Application No: BE/149/20/PL
Site Address: 339 Chichester Road Bersted PO21 5AN
Description of works: Replacement of blockwork boundary wall with fence & new vehicular access. This site is in CIL Zone 4 (Zero Rated) as other development.

Thank you for your internet representation made on 11th January 2021 which has been recorded as an objection with the comments as follows:

SITE PLAN

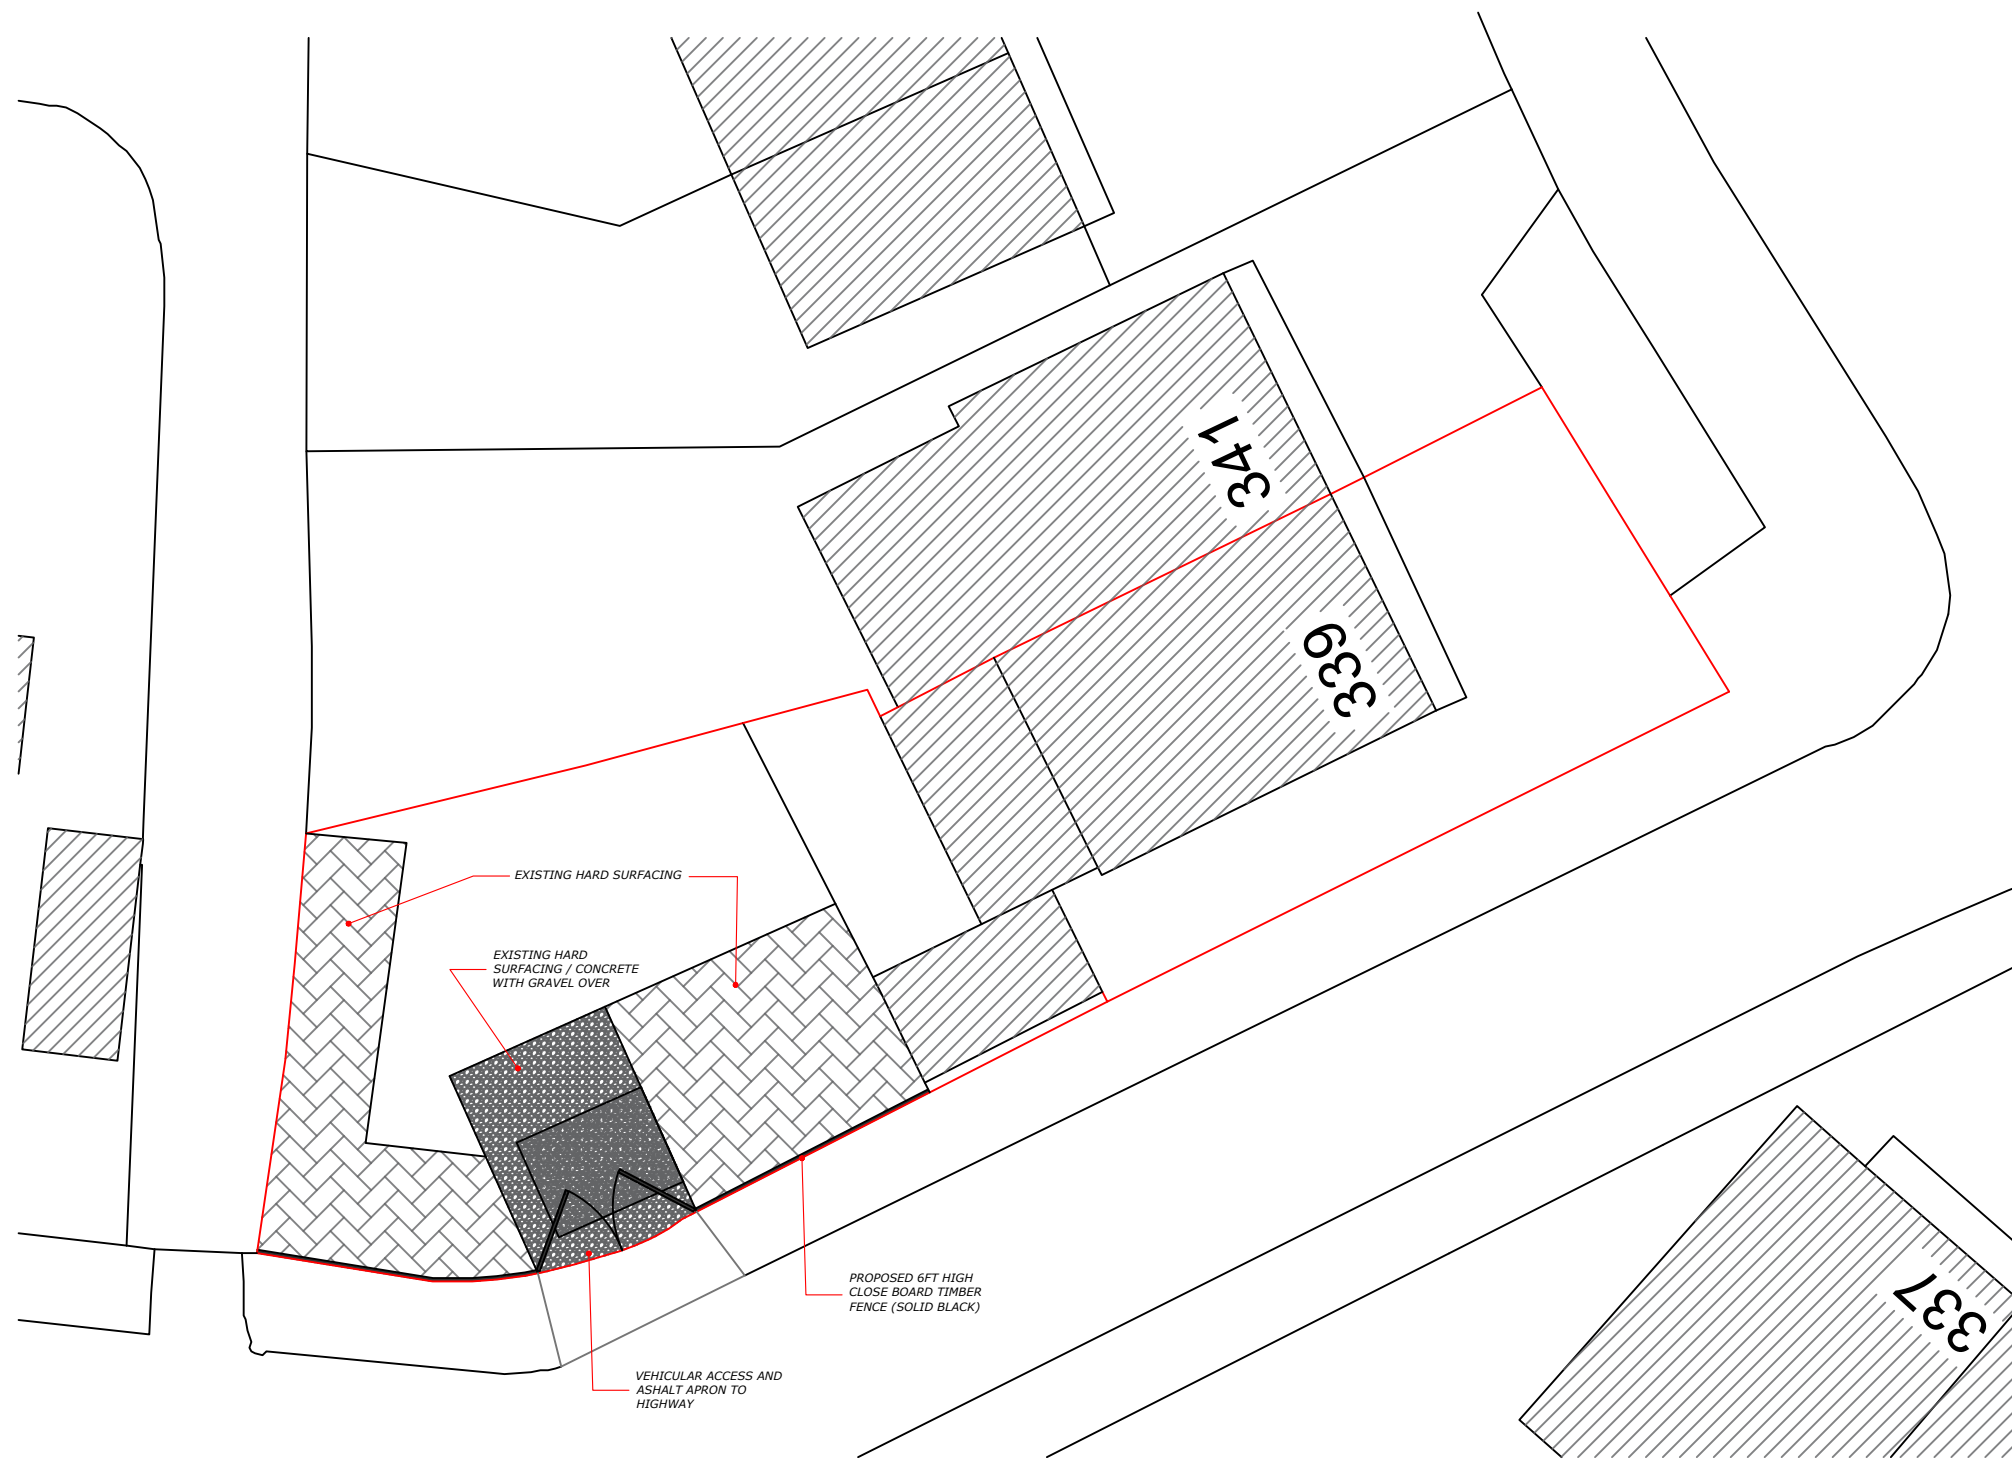
The proposed Planning Application for 339 Chichester Road should be refused. The placement of a dropped kerb in the location is hazardous. It is to be located on a blind bend which is normally surrounded by residents parked cars which are already up on the kerb. It is also opposite an alleyway, and back entrance providing access to houses along Chichester Road. This is a serious safety issue as pedestrians, schoolchildren and vehicles use this access and it is already dangerous in term of view and location on the bend. To site an entrance in any form opposite this is to invite an accident. There have already been near misses with both cars and pedestrians as the line of sight is obstructed as previously mentioned. The site is being quoted as being used for residential purposes, however until previous complaints were raised objecting to the dropped kerb, it was being used as a business premises, alongside emergency residential accommodation. This resulted in vans, cars and extra traffic along the road (which is already busy) and outside the houses making an already difficult situation even more so. If the site is being used for residential purposes there is already a dropped kerb with parking for approximately 4 cars at the front of the property, so i fail to understand why more parking would be needed. Since the previous objections were raised the premises has been noticeably quieter with less traffic and predominantly only residents vehicles in attendance. Occasionally the vans for the business do appear but not as frequently as before. When this happens they are not now parking outside and across peoples driveways, or on double yellow lines and blocking the road as they were during and towards the end of 2020. The location of any more residential properties, the dropped kerb, and access opposite an already dangerous bend would only serve to make it dangerous to all and it is no way needed. We strongly object to this application in all forms.
